GATEWAY 36, BARNDSLEY
ROCKINGHAM - PHASE 2B

UNIT 7

MITIGATION MEASURES

Response to XQLA Landscape Review - rev. B

**334 - Gateway 36**  
**Rockingham, Barnsley**

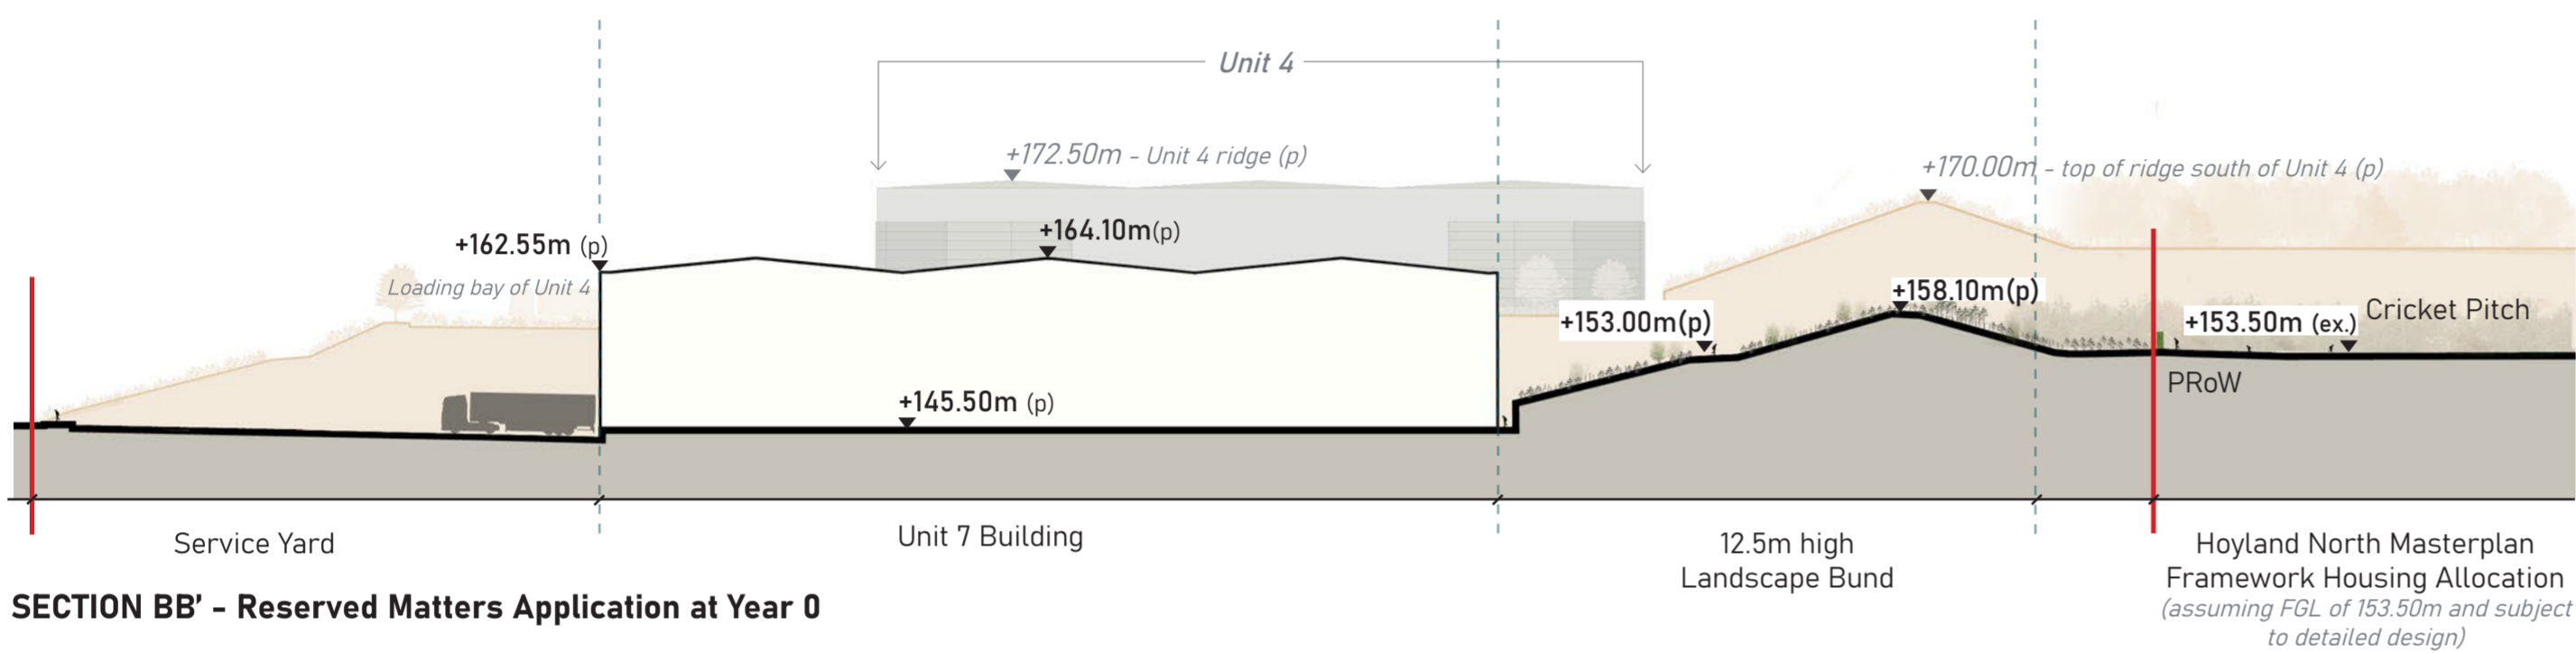
- The variation in bund height has been illustrated in **Fig. 4** using schematic sections.
- The ridge height, 12.6m (158.1m - 145.5m) represents the maximum height achievable considering both the structural stability of the mound and existing embankment (at 1:3 slope), available on-site surcharge material and the constraints of space to the rear of Unit 7.

- Therefore, there is no scope to increase the height of the bund further.
